**Recommendation Report for Planning Permission for Works or Extension to a Dwelling**

**REF NO:** LU/99/14/HH

**LOCATION:** 19 Clarence Avenue  
Littlehampton

**PROPOSAL:** Retention of some existing fencing & gate & replacement of remaining fencing to side South boundary. This application may be determined by Littlehampton Town Council under delegated powers

PROJECT
19 CLARENCE AVENUE
WICK
LITTLEHAMPTON
WEST SUSSEX
DRAWING TITLE
EXISTING FENCING AND GATES

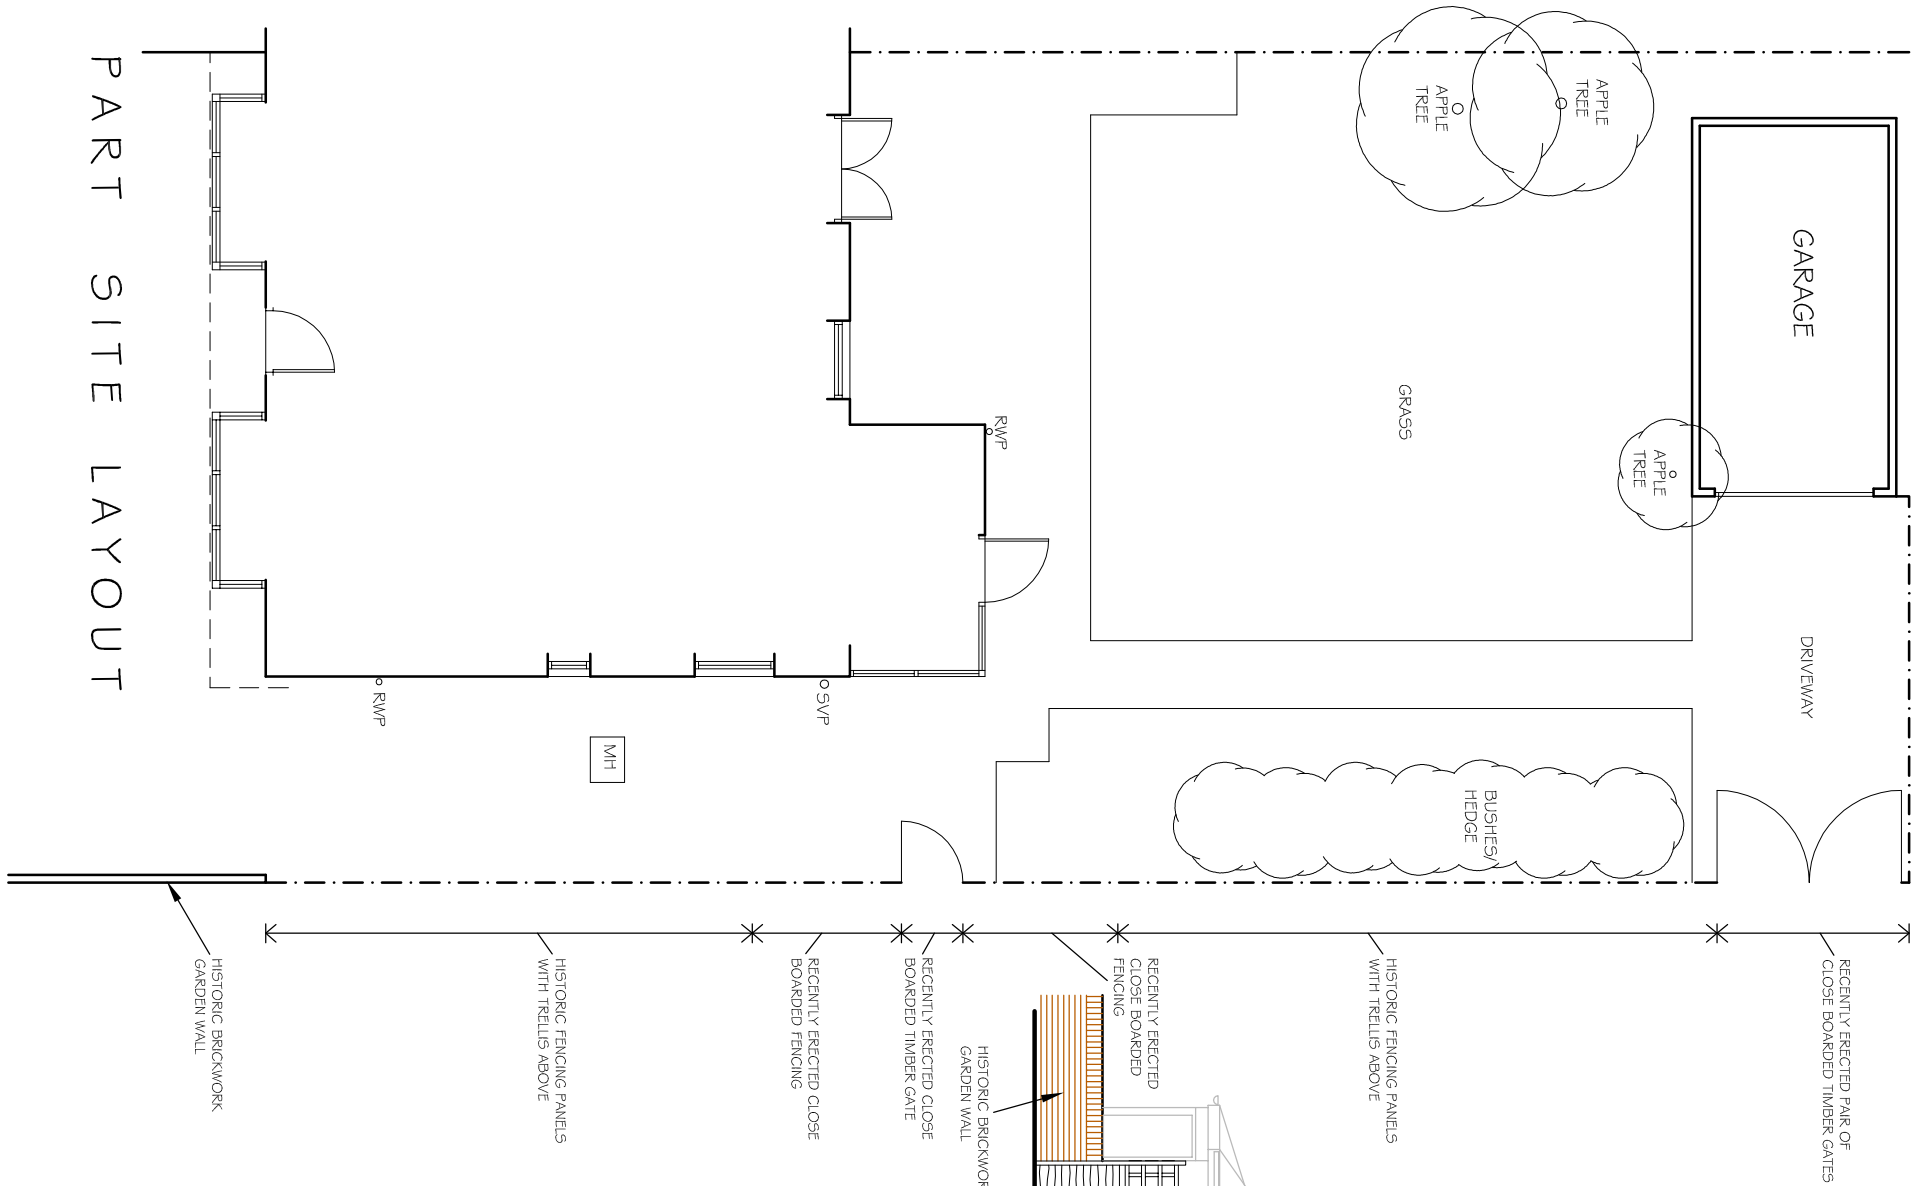
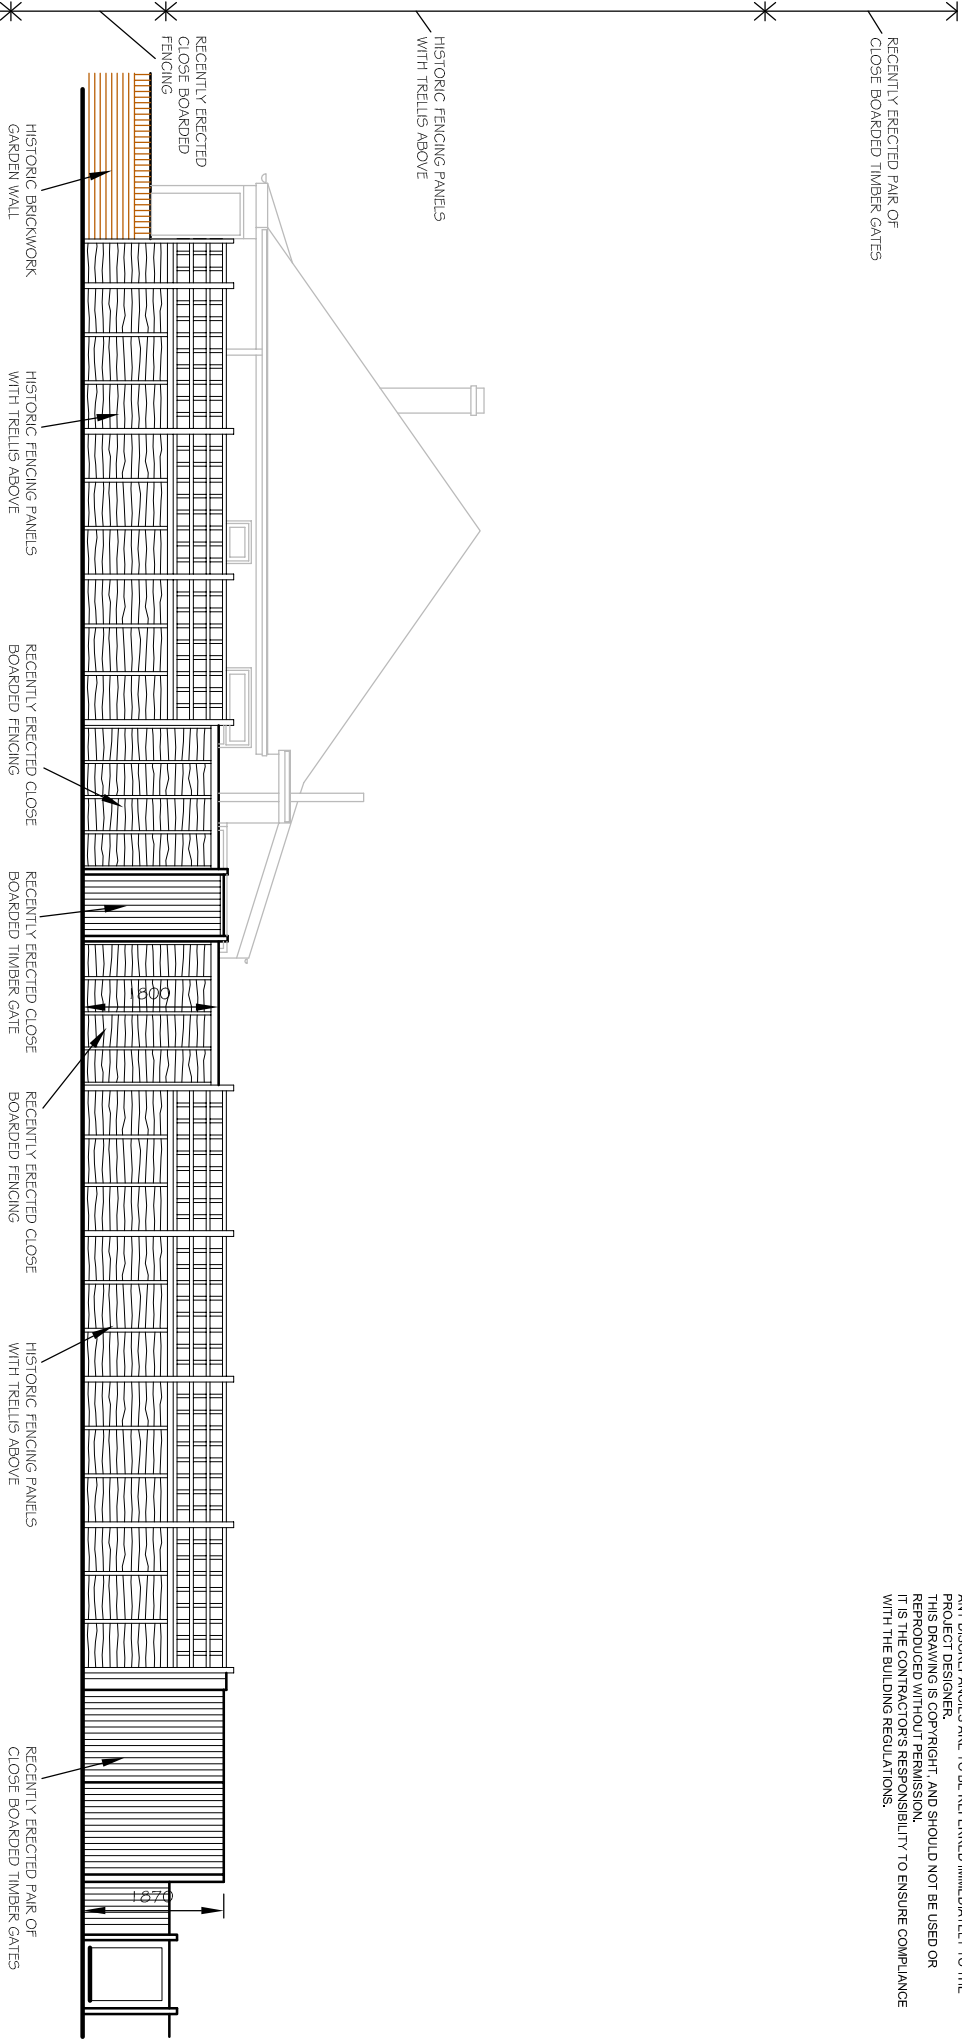
This application seeks the retention of two new fence panels either side of a new gate and a pair of new gates which are currently in situ as well as the replacement of the existing fencing and

trellis elsewhere with new fencing. The gates and two sections of fence panels in situ adjoin the existing wooden fencing with trellis on top and are slightly lower at 1.87m in height. The fence panels and gates are visible in the street scene. The replacement fencing is to match the new fence and gates in height, material and appearance.

The fence panels and gates that are already in situ have not been stained and consequently appear unacceptably prominent in the street scene. However, it is recommended that a condition be imposed on any permission requiring that details be submitted to ensure that these panels are to be stained with a colour to be first agreed with the Local Planning Authority. With such a condition in place, it is considered that the proposal is acceptable in visual amenity terms.

- 3 Within one month from the date of this permission, details of the staining/painting of the fencing and gates hereby approved and those in situ shall have been submitted for the written approval of the Local Planning Authority. Within one month of the details having been approved, the staining/painting will be carried out to those fence panels and gates currently in situ and maintained in perpetuity thereafter. The agreed staining/painting shall be applied with immediate effect upon erecting the new fence panels hereby permitted and maintained in perpetuity thereafter.
